**West Yorkshire Police
Kirklees District**

Architectural Liaison Officer

To: Adam Walker	Ref: 2018/92934 Date: 22 nd January 2019
-----------------	--

**Proposed site: Former Gees Garage, New Hey Road, Oulane, Huddersfield HD3 3YJ
Application for: 21 Houses**

DRAWING NUMBER: 2554/1 - 02

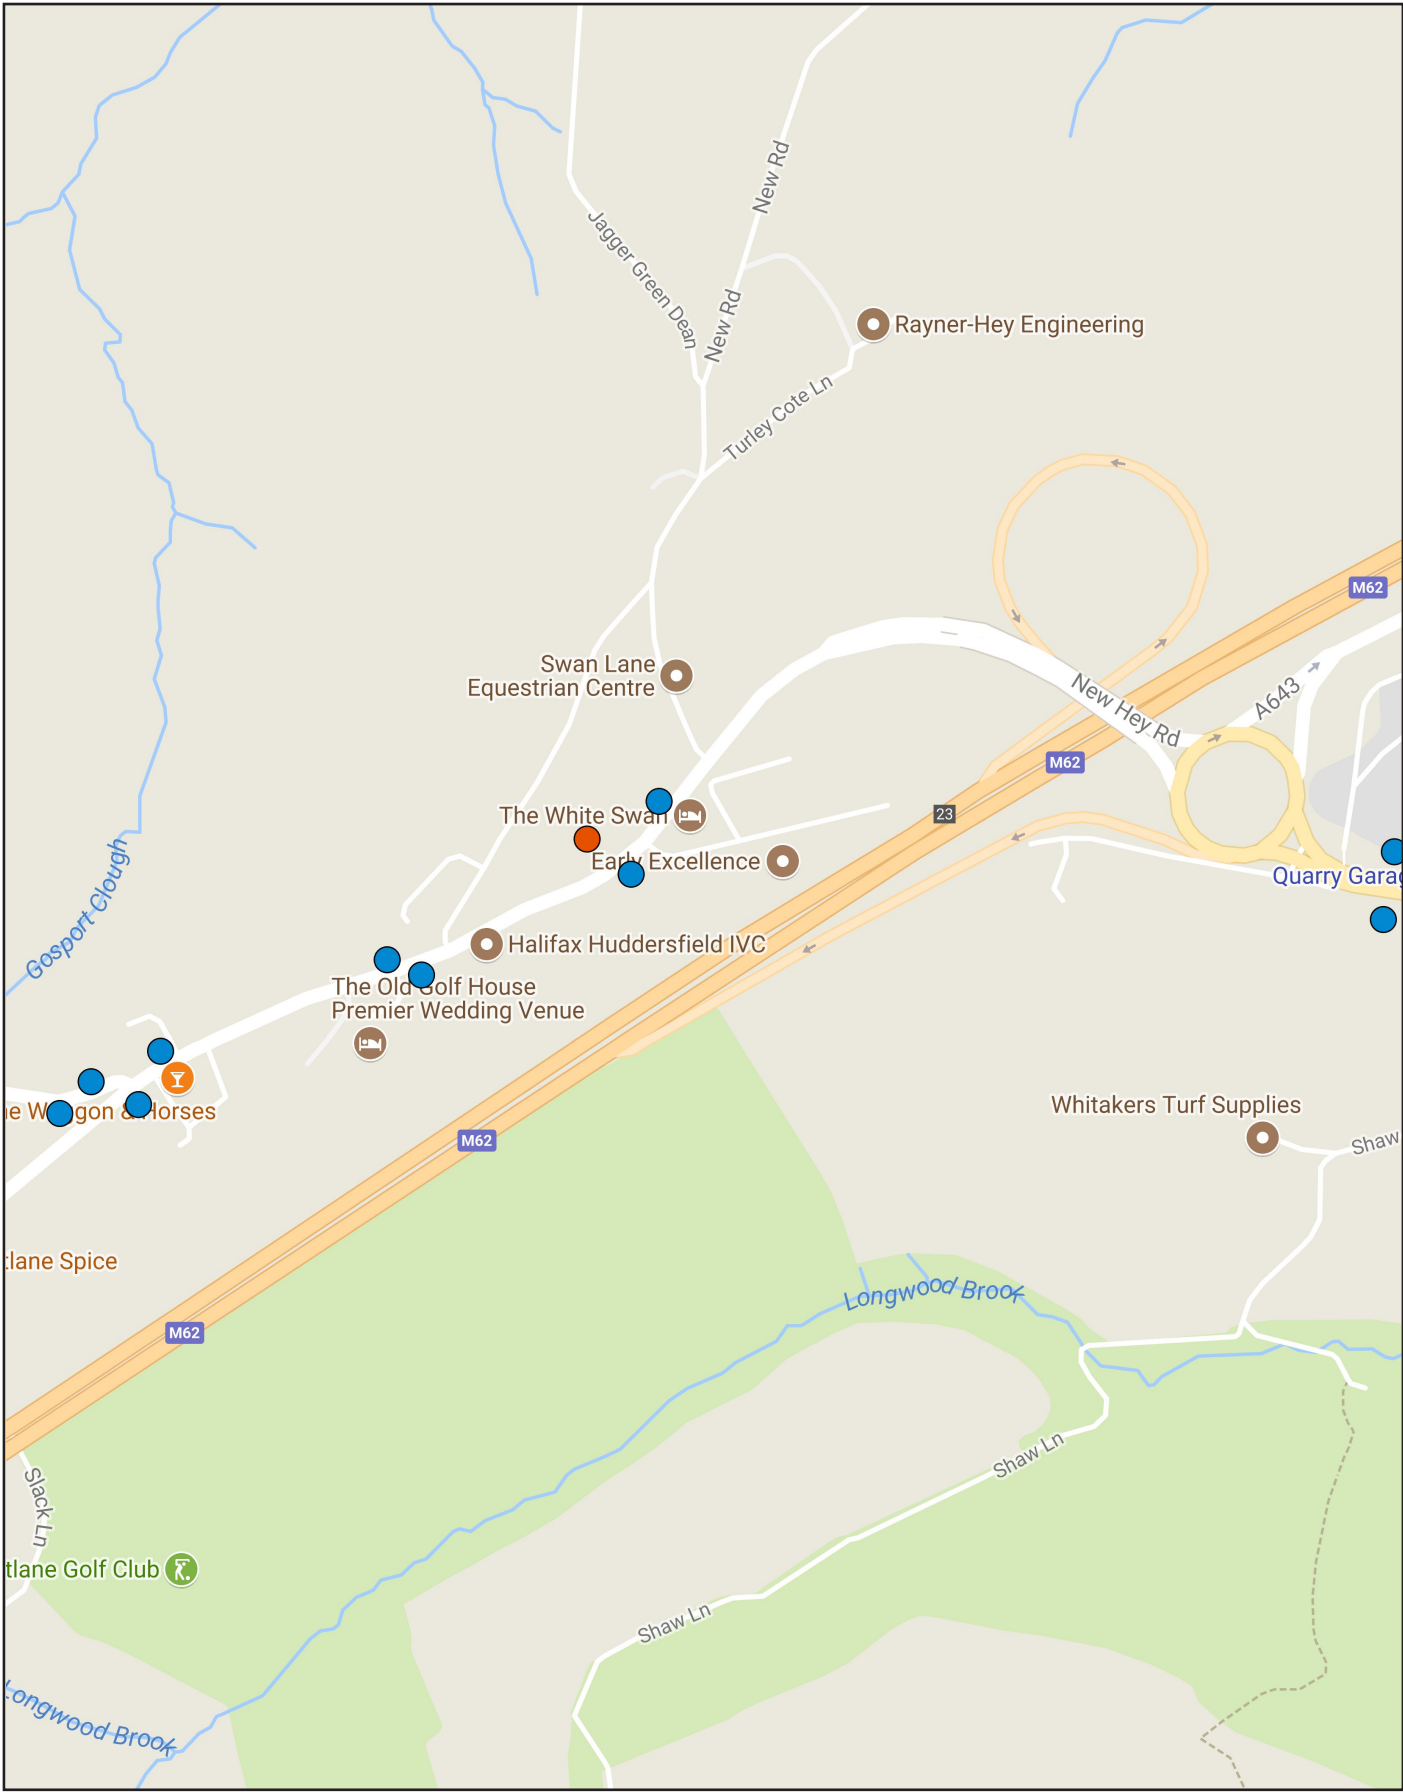
The plots 13 to 19 shown on drawing number 2554/1-02B show that the rear of these properties border on Mulehouse Lane. This lane allows for an easy and secluded escape route away from the site for would be offenders. Rear flush closed boarded timber fencing facing the lane should be at least 1.8m in height with 500mm trellis topping to deter climbing.

Should enough space be available between the lane and the rear fencing of plots 13 to 19, additional defensible planting is advised using *Pyracanthus* or *Berberis* type hostile plants to keep intruders away from the fencing. There should be a maintenance programme to keep this vegetation to a maximum height of 1m from the ground.
